**Consultation Response from KC,
Highways Development Management**
2022/92633 Land off, Carr Hill Road, Upper Cumberworth, Huddersfield, HD8 8XN
Demolition of store and stable block and erection of one dwelling
Date Responded: 31/10/22
Responding Officer: CNB
Responding Ref: K12-45/9

Prop. Site
1 : 500

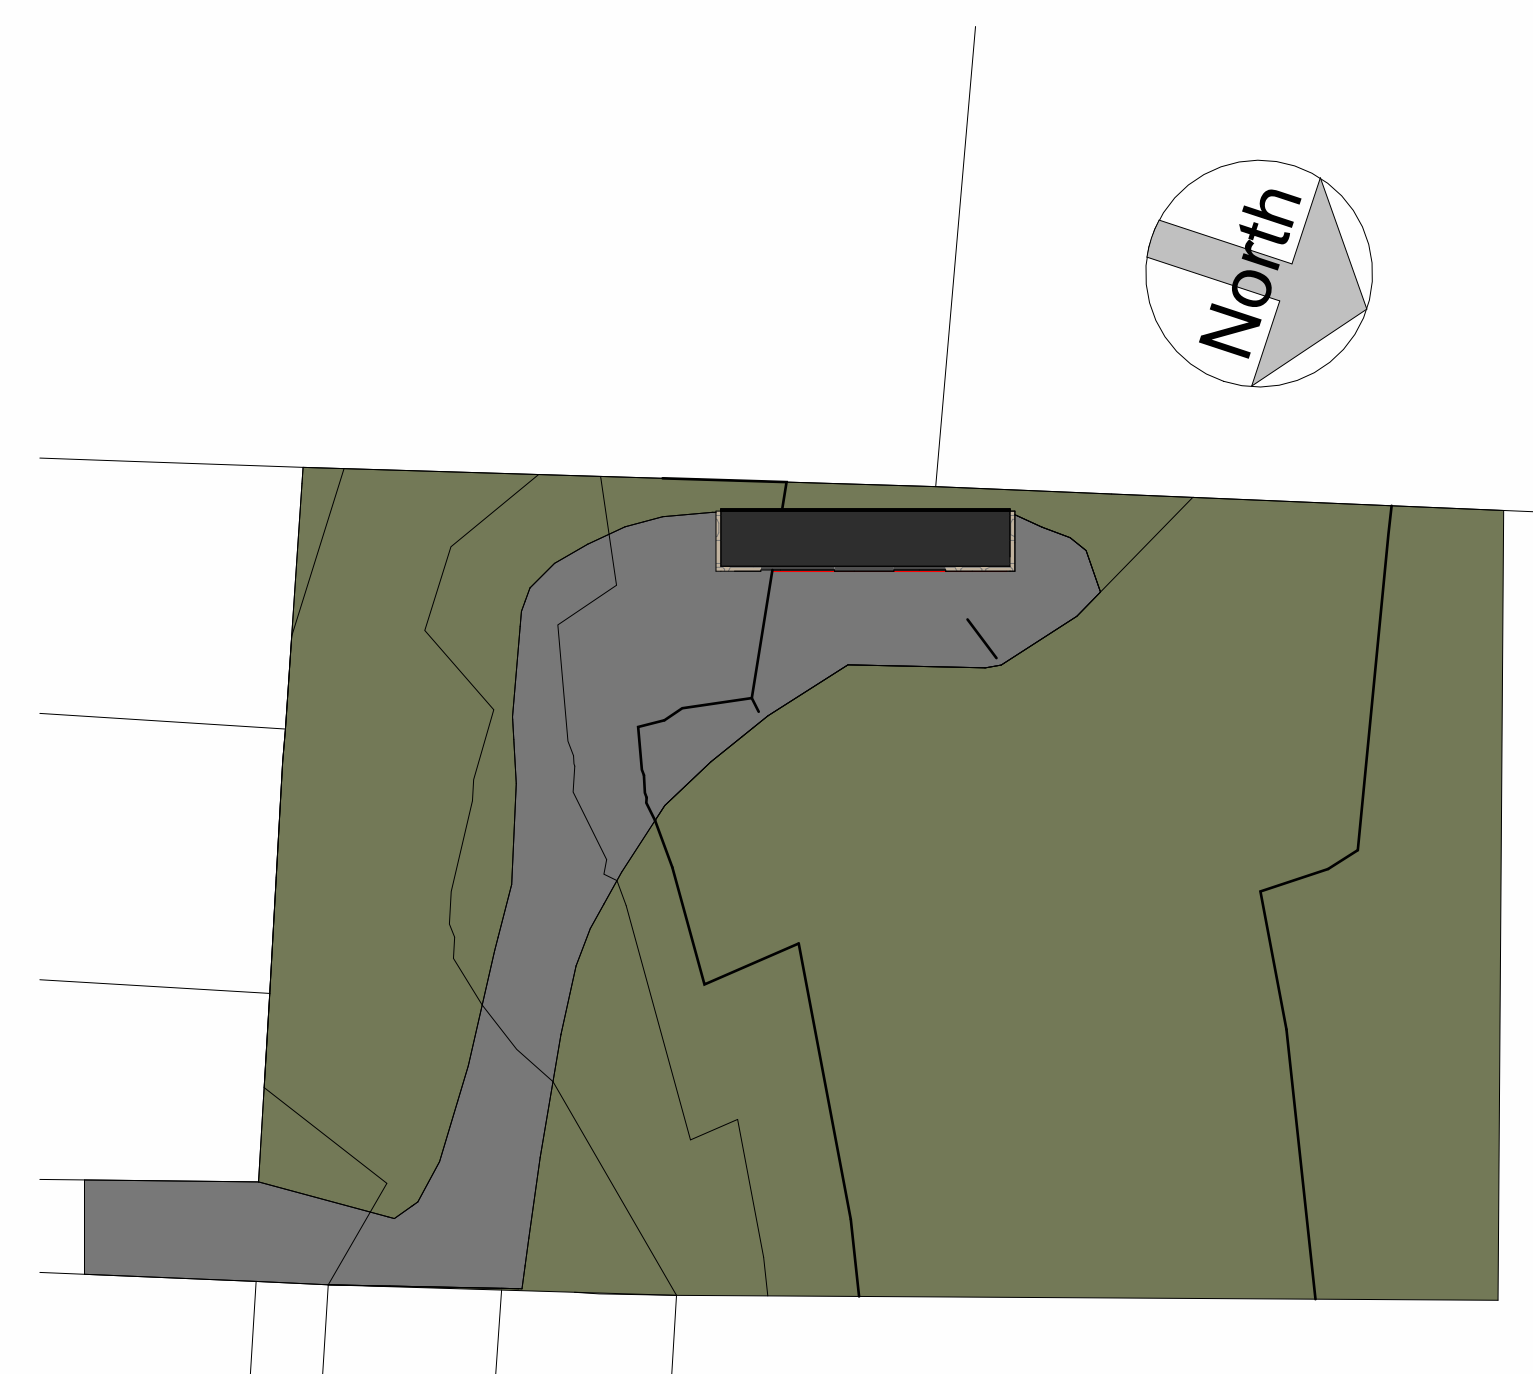
The access is existing but is a field access and so we would expect this to be improved for use as access to a dwelling. This will need to be done within a s184 legal agreement with the council and a suitable footnote should be added. If the drive is to remain unsurfaced, then we would require that the first 5m of the drive is surfaced in a solid material to avoid loose soil and mud from being dragged on to the highway for road safety reasons and this should be conditioned.

The driveway is approximately 125m from the adopted highway to the proposed dwelling and is currently approximately 5m width and this would only be suitable as a single track and so we could only accept a single dwelling using the access otherwise we would require it to be suitably widened. This access be acceptable for an emergency fire tender at this width.

The site is currently gated and if this gate was to remain, we would like to see it set back 5m from the rear of the highway so that cars waiting for the gate to be opened can pull clear of the highway for road safety reasons. The gate should also be set to open inwards only again for highway safety reasons and both should be conditioned.

The dwelling is proposed to have two bedrooms and for a dwelling of this size, local guidance requires 2 off street parking spaces. No details were provided regarding the location of parking spaces and so we would like to see them clearly marked on a drawing with suitable turning space also clearly marked so that vehicles can enter and exit the site in forward gear for road safety reasons. As there appears to be sufficient space to the front of the dwelling for this parking and turning, it should be added as a condition.

Details of the surfacing for the parking, turning and driveway areas should be provided, again marked clearly on a drawing, along with any drainage from this parking area if the finish is to be impermeable.

No details were provided relating to waste storage and collection and a collection presentation point should be clearly shown on a drawing as close to the rear of the adopted highway as possible but not where it would cause an obstruction for highway safety reasons. This should be conditioned.

Notwithstanding the details shown on the approved plan, no development shall take place until a scheme detailing arrangements and specification for layout of access, turning and parking have been submitted to and approved in writing by the Local Planning Authority. Before any building is occupied the development shall be completed in accordance with the details shown on the approved plans and retained thereafter.

Before the access is used for vehicular purposes, that part of the access extending from the highway boundary for a minimum distance of 5m into the site shall be appropriately paved in tarmacadam, concrete, block paviours or other approved materials.

Notwithstanding the provisions of the Town and Country Planning (General Permitted Development) Order 1995, (or any order revoking and re-enacting that order) any gates or barriers for or over a vehicular access or egress shall be set back 5m from the back of the carriageway of Carr Hill Lane and shall be hung as to only open inwards. So long as such gates or barriers are in position they shall be retained to only open inwards.

Before development commences, details of suitable storage, bin presentation points and access for collection of wastes from the dwelling hereby approved shall be submitted to and approved in writing by the Local Planning Authority. The approved details shall be provided before first occupation and shall be so retained thereafter.
